Development Facilitation Team (DFT) – Review Comments

Project No: PR-2024-009976 Date: 08/14/2024 Agenda Item: #1 Zone Atlas Page: G-16

Location: 4010 Carlisle Blvd NE between Hilton and Hahn Arroyo Channel

Application For: SD-2024-00114 – VACATION OF PUBLIC RIGHT-OF-WAY

ALTA/NSPS LAND TITLE SURVEY

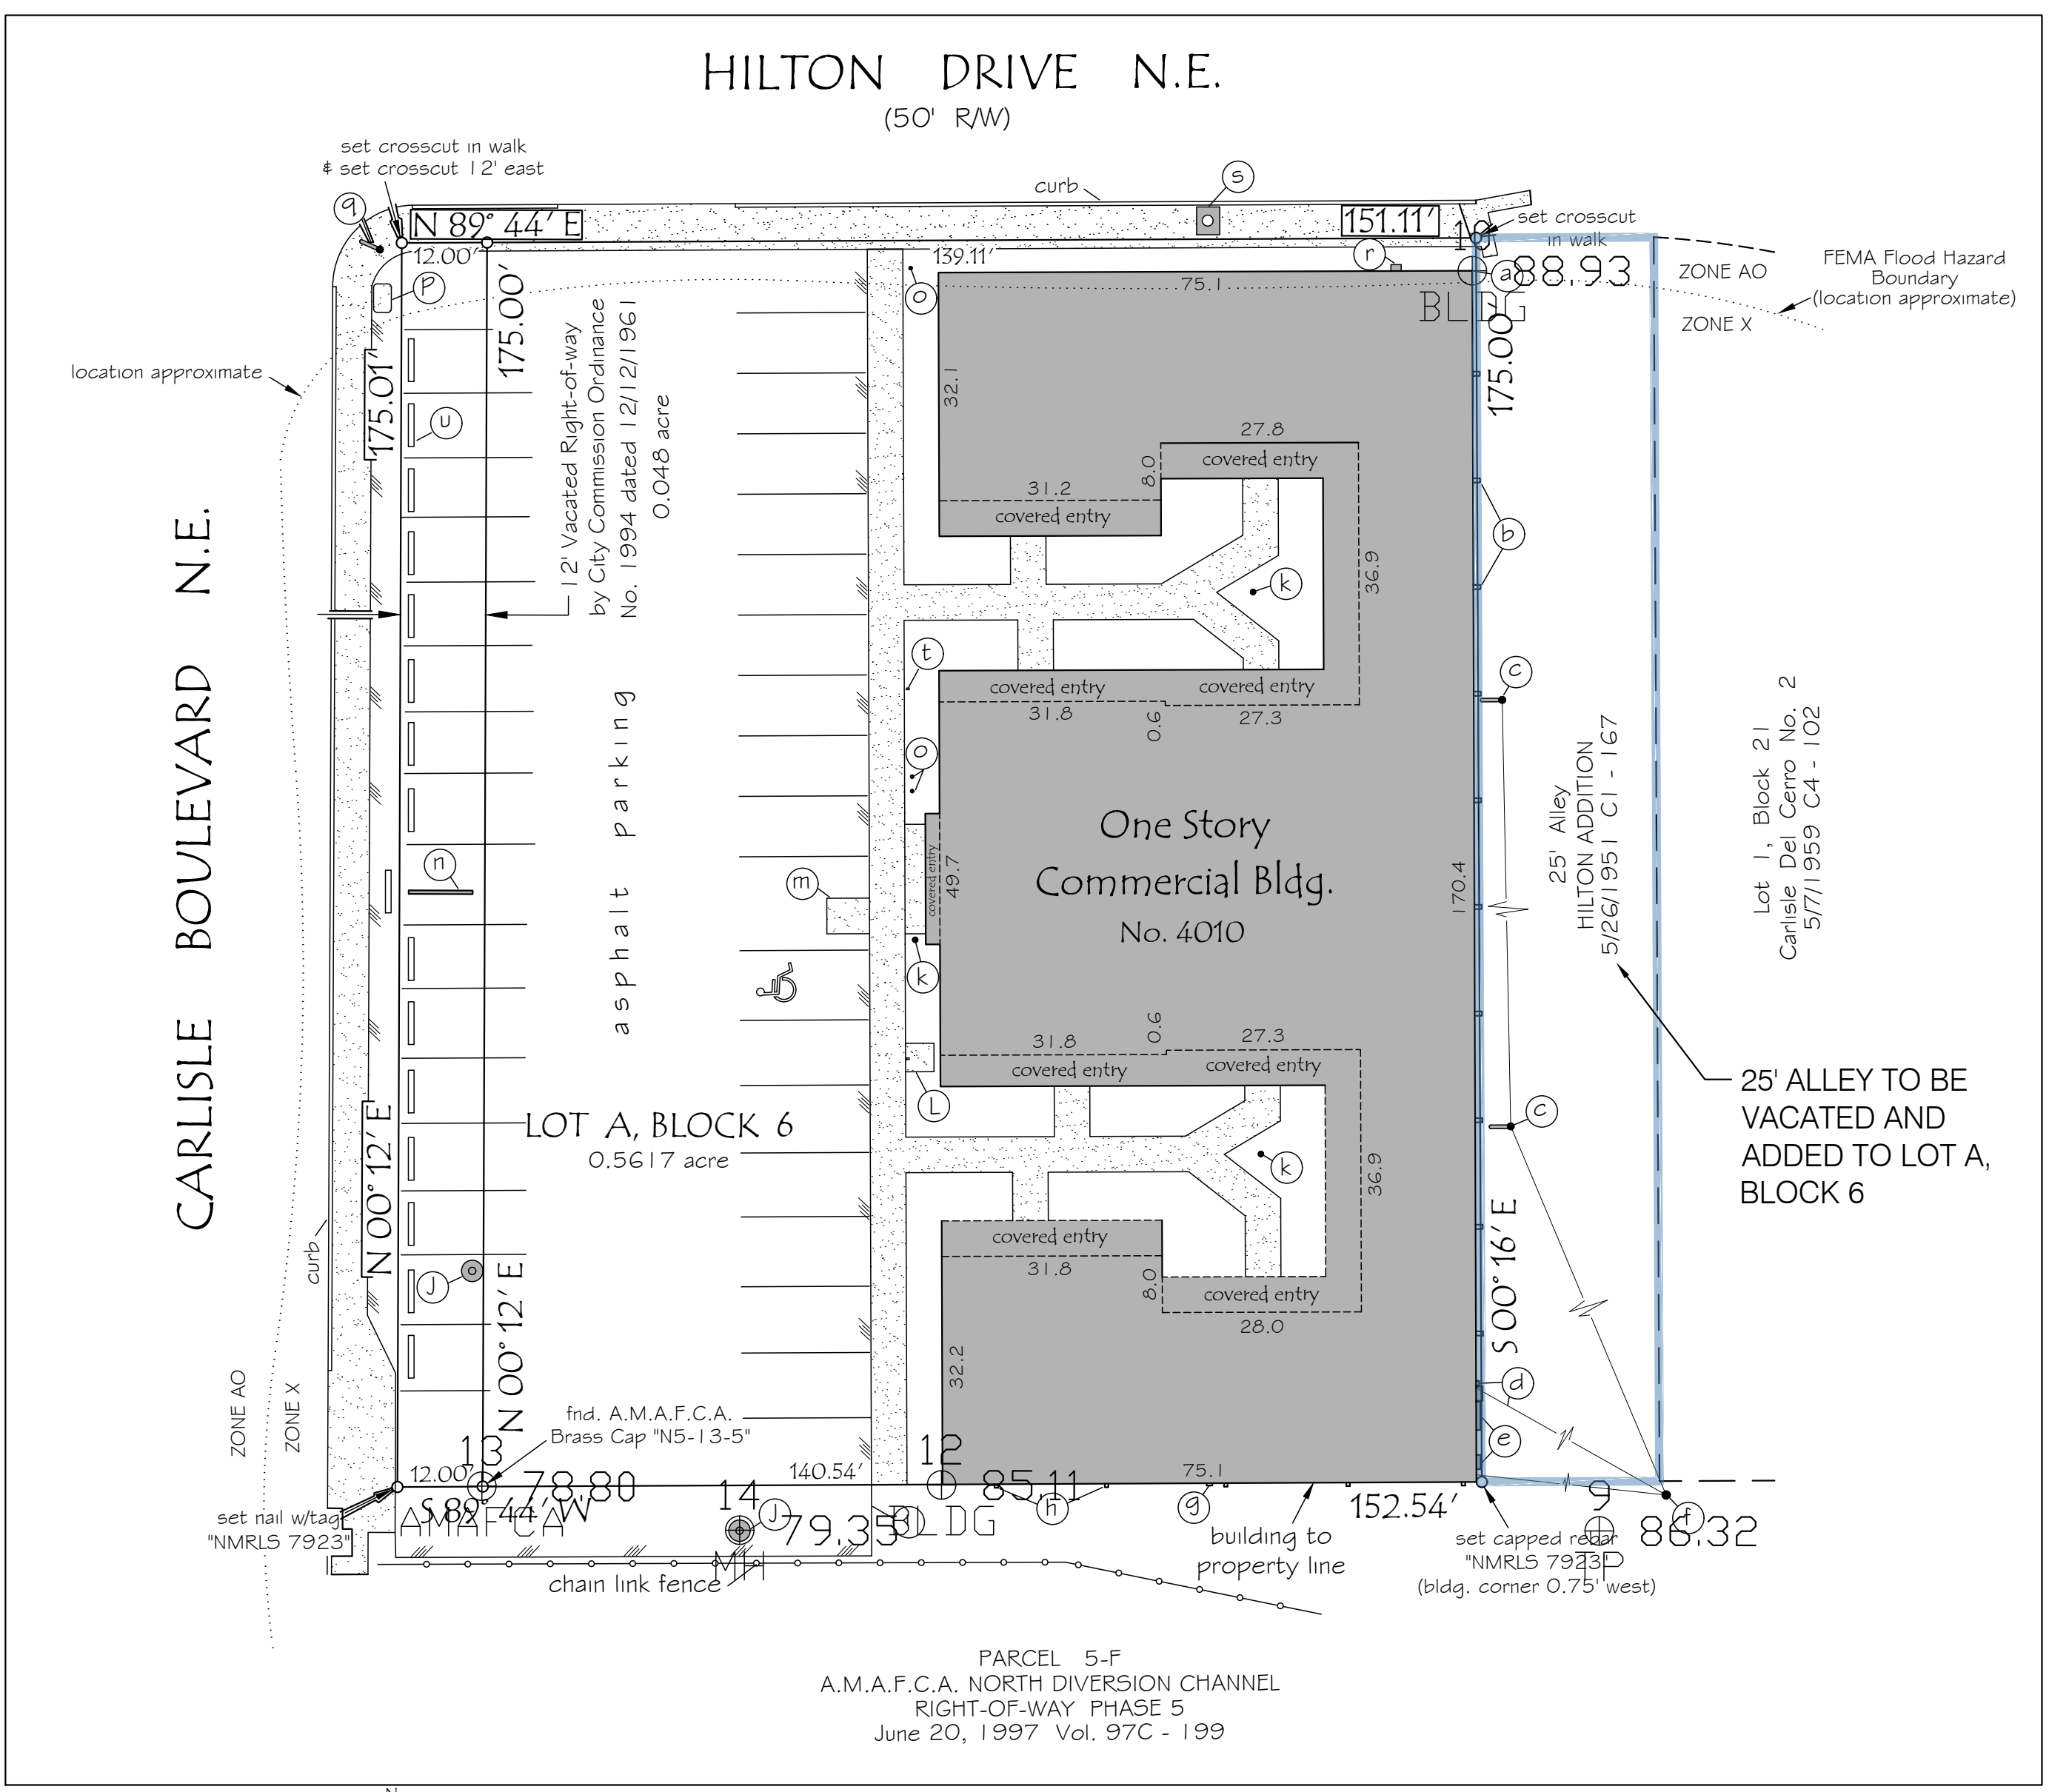
2. Please show width of existing sidewalks and landscape buffers. Carlisle is a Minor Arterial and requires 6' sidewalk with 5' to 6' landscape buffer. Hilton is a local road and requires 5' sidewalk with 4' to 6' landscape buffer. If you are not able to provide the required width you may request a determination with a justification letter.
3. Please list ROW width for Carlisle to ensure it meets City standards in the DPM.
4. It appears that existing property lines along Hilton encroach on the public sidewalk. ROW dedication will be required to ensure sidewalks are completely in City ROW.
5. For future development, an approved TCL will be required prior to site plan approval.
